Our ref: St Anthony of Padua Catholic School Redevelopment-Mod-2 (SSD-8865-Mod-2)

10 August 2022

Subject: Response to Submissions

**Figure 13** | Tree 496, proposed and revised sediment and erosion plan (Base source: Applicant's Modification Report and SRtS 2022)

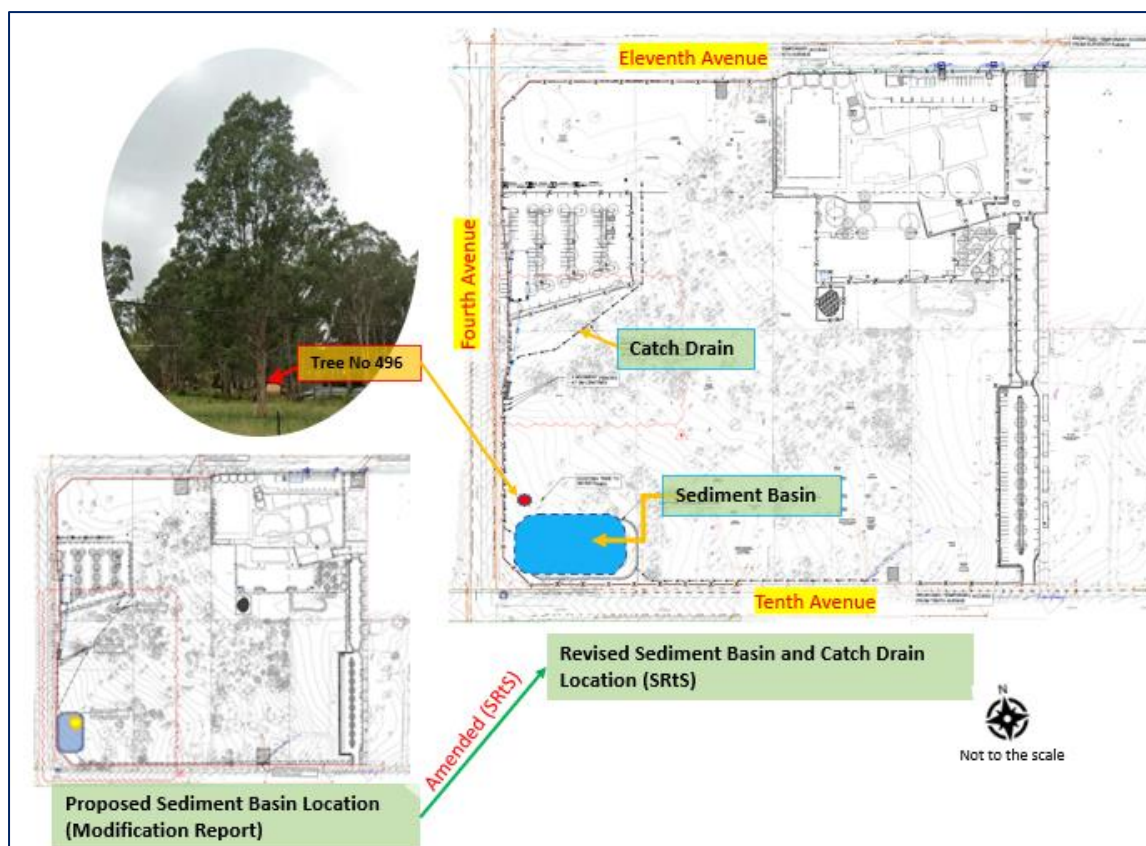
- The Department agrees with the comments from Environment and Heritage Group regarding the impact of the modification on the Cumberland Plain Woodland, including Tree 496. The Department requires you to amend the Preliminary Sedimentation and Erosion Control Plan, Preliminary Bulk Earthworks Cut and Fill Plan and landscape plans to address the concerns of the Government agency.
